From: Rael, Rudy E.
Sent: Thursday, January 19, 2017 10:03 AM
To: 'Metro, Steven J. (Steven.Metro@wilsonco.com)'
Subject: 6512 Papagayo

Based upon the information provided in your submittal received 1/17/17, the above referenced Grading and Drainage plan dated 1/17/17 cannot be approved for Grading Permit until the following comments are addressed:

GRADING AND DRAINAGE PLAN
LOT 1, BLOCK 8, UNIT 18, VCS
ADDRESS: 6512 Papagayo Rd NW

GRADING AND DRAINAGE PLAN
LOT 1, BLOCK 8, UNIT 18, VCS
ADDRESS: 6512 Papagayo Rd NW

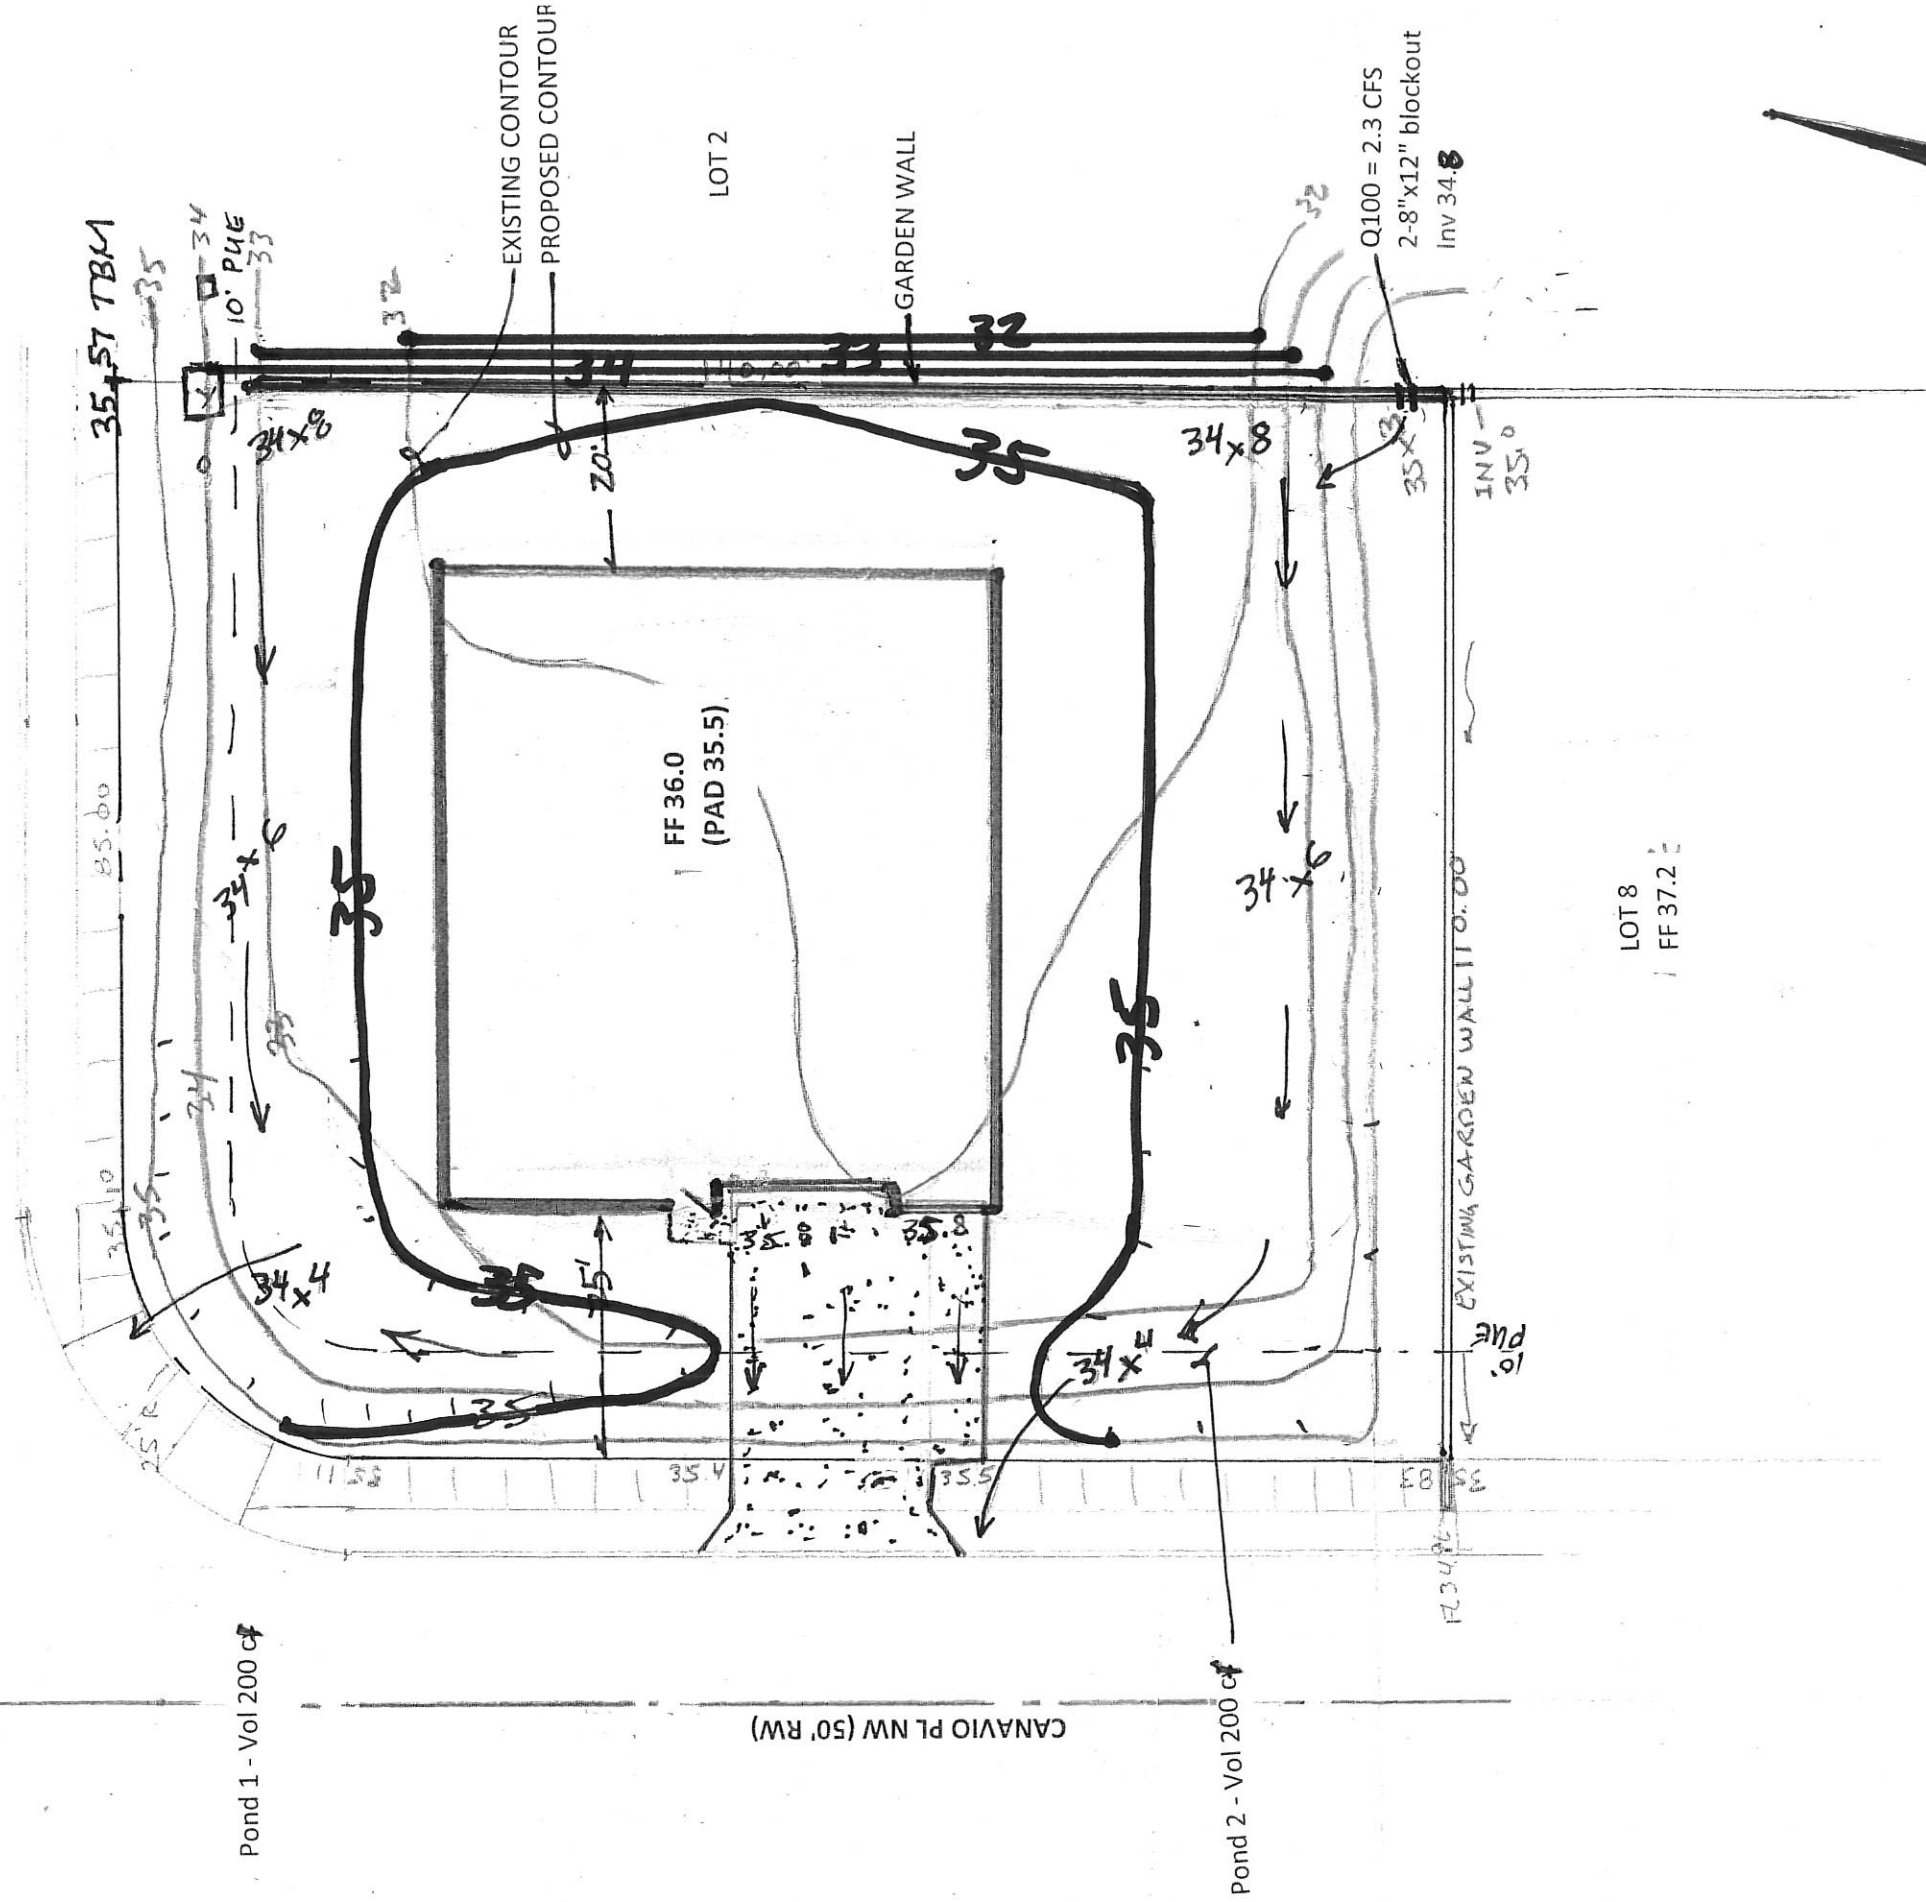
- Provide a note stating that future garden walls require a separate permit and this plan should be used for their placement.
- Also state that future garden walls require an opening 3" above grade in the SW corner.
- Provide a statement that a pad certification is required before a building permit is given.
